# Memorandum

**Date:** July 24, 2025

**Re:** Fire Station 4 – Final Sign-off of Site Plan-EPC (PR-2024-010349/SI-2024-01085)

TOTAL PROVIDED:
41 SPACES TOTAL ON SITE, OF WHICH 2 ARE HC ACCESSIBLE

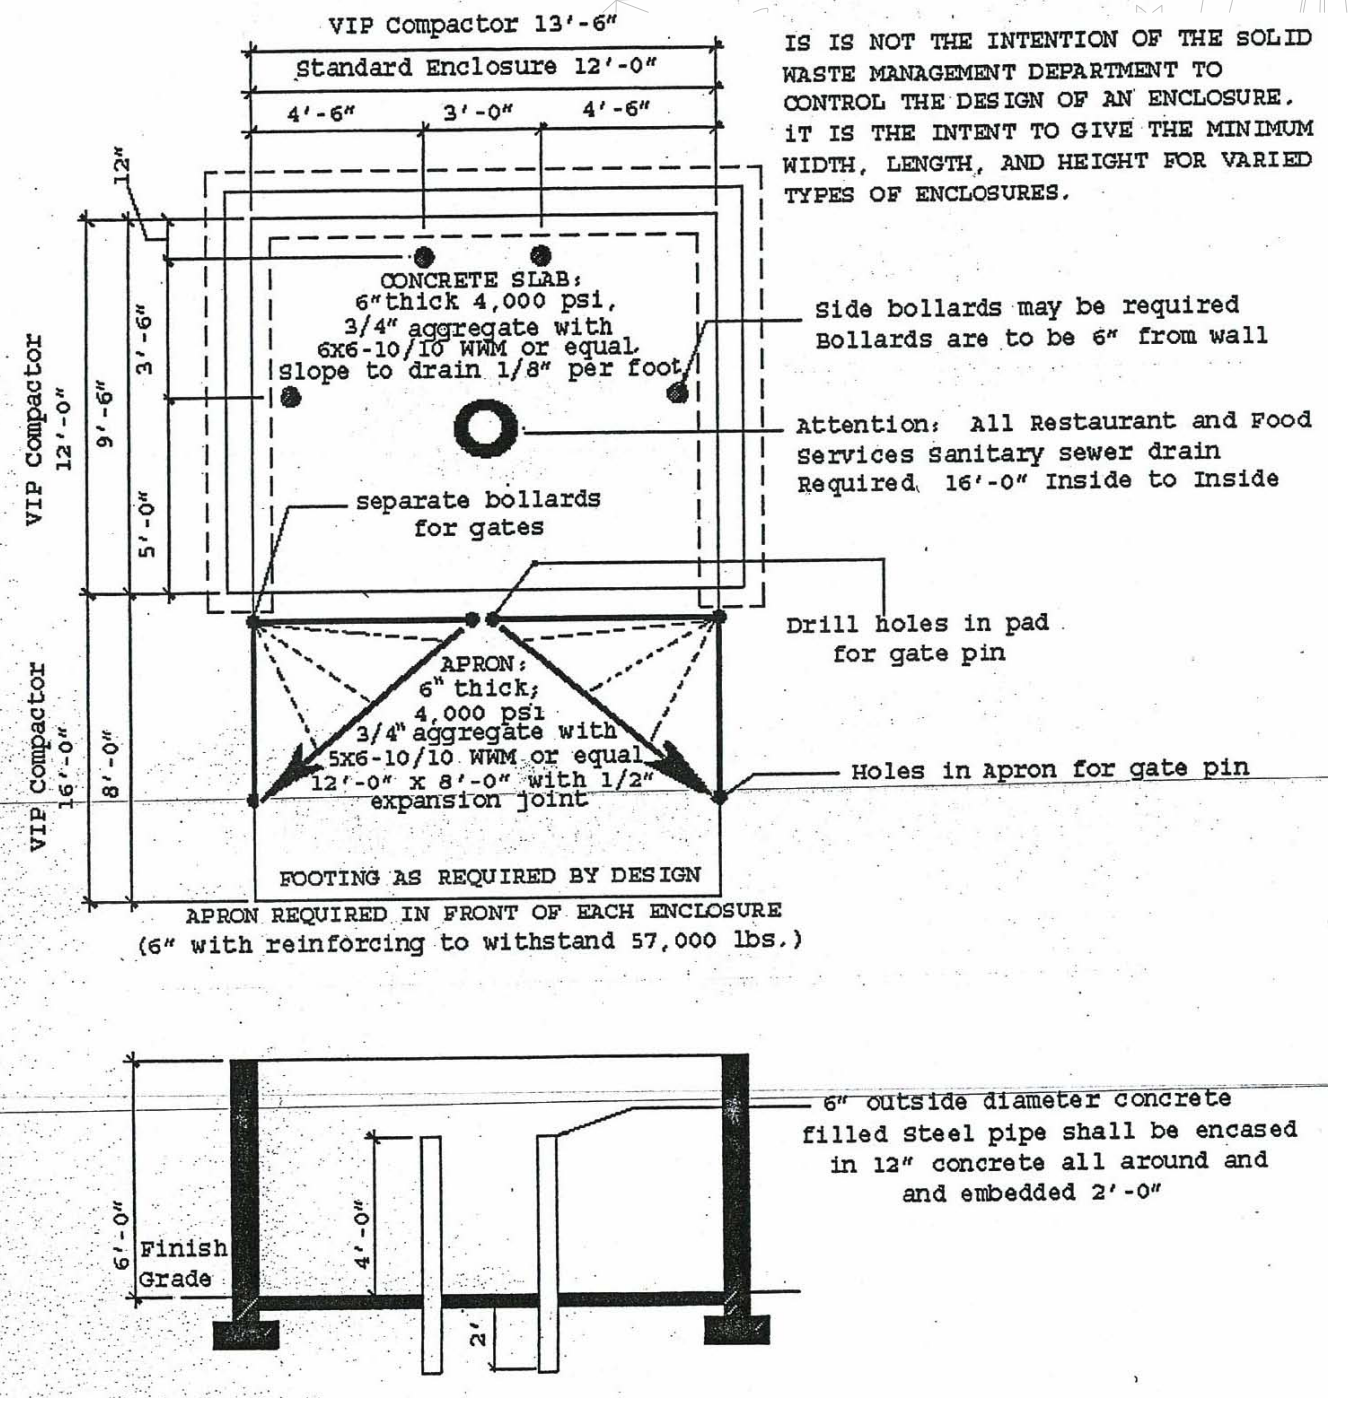
- *The provided EPC Site plan calls out a total of 41 parking spaces, 2 ADA parking spaces, and 2 motorcycle parking spaces. The provided drawings show a total of 44 parking spaces with 2 ADA spaces. Confirm how many parking spaces are being made available and ensure the correct amount are displayed on the site plan.*

**Applicant Response:** The site plan shows 46 parking spaces, two of which are ADA accessible. The parking calculations were revised to reflect the accurate number of parking spaces.
